At a virtual meeting of the Planning & Environment Committee of Barnham and Eastergate Parish Council held on Tuesday 21st July 2020 the Committee resolved to submit the following comments as an objection:

Application No: BN/58/20/HH
Registered: 11th June 2020
Site Address: Veronicas Park Road Barnham PO22 0AQ

Description of Works: Demolition of conservatory. Single storey rear and side extension.

Drawing P01a May 2020 Scale 1:100 @ A3
Planning Drawing - Floor Plan & Elevations

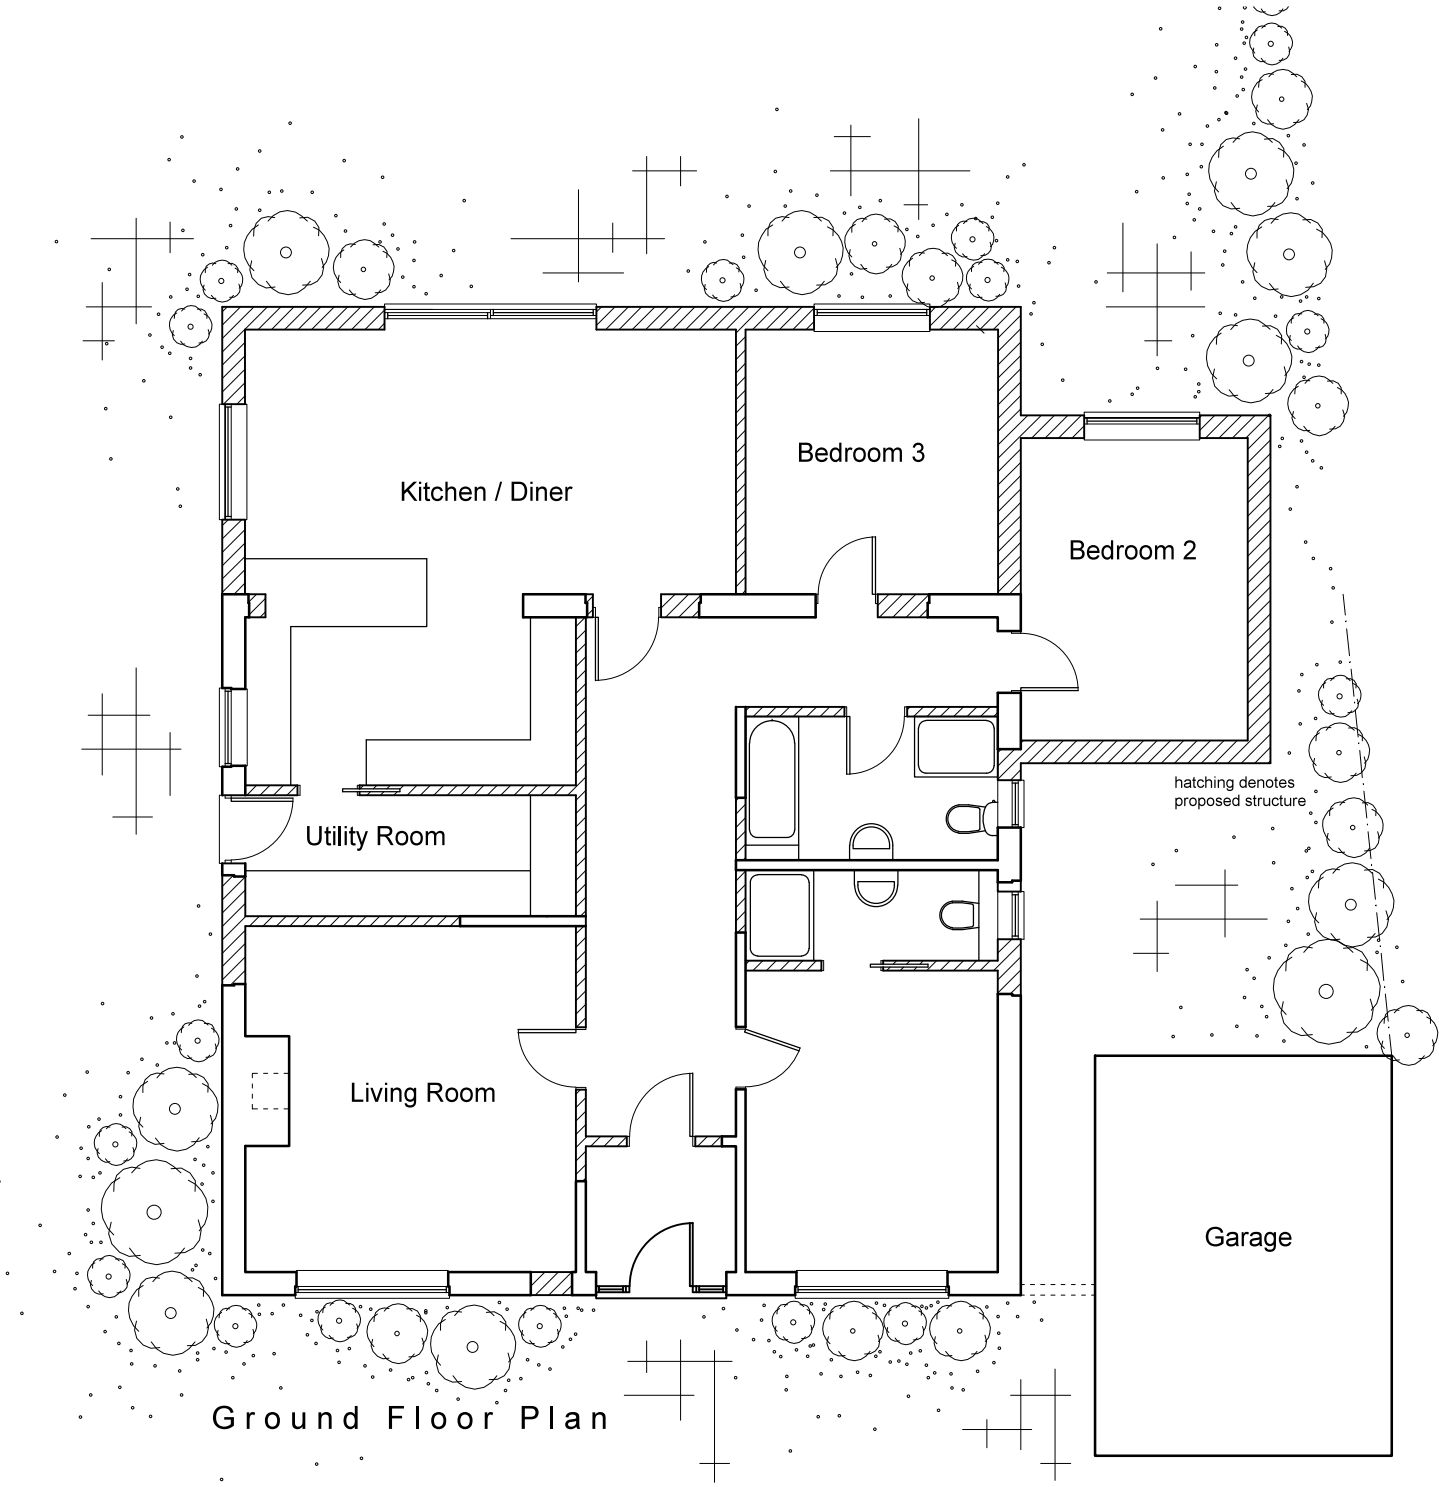
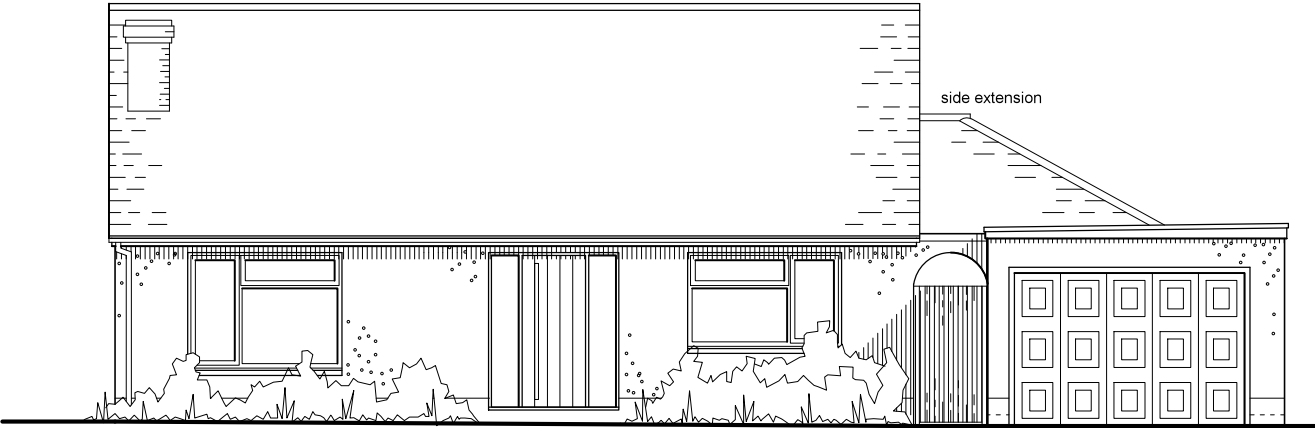
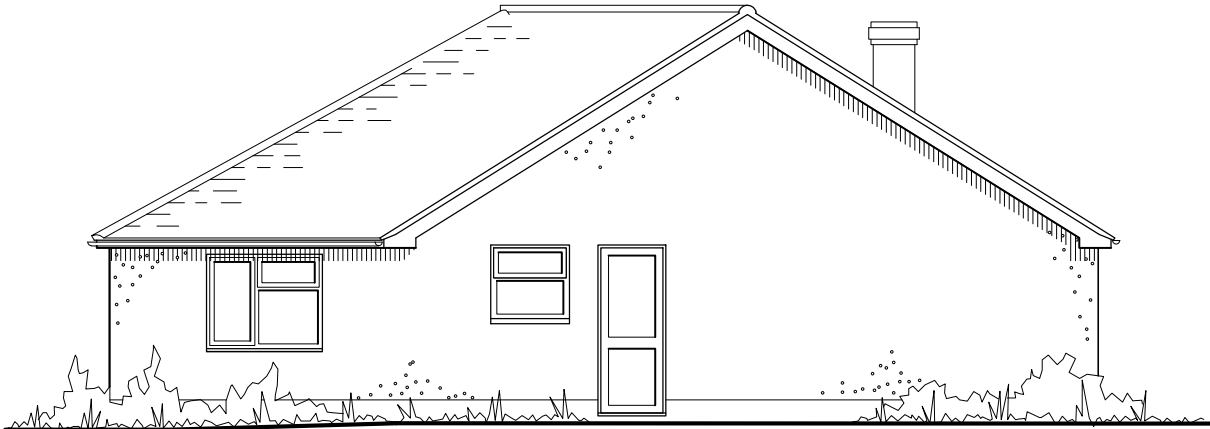
The proposed extension would appear to be extremely close to the neighbouring property and the Council would hope that the neighbour was aware of the proposed application.

The size of the extension would appear to perhaps be outside the limits of permitted development but the plans were not very clear. A more sympathetic size of extension might be considered.
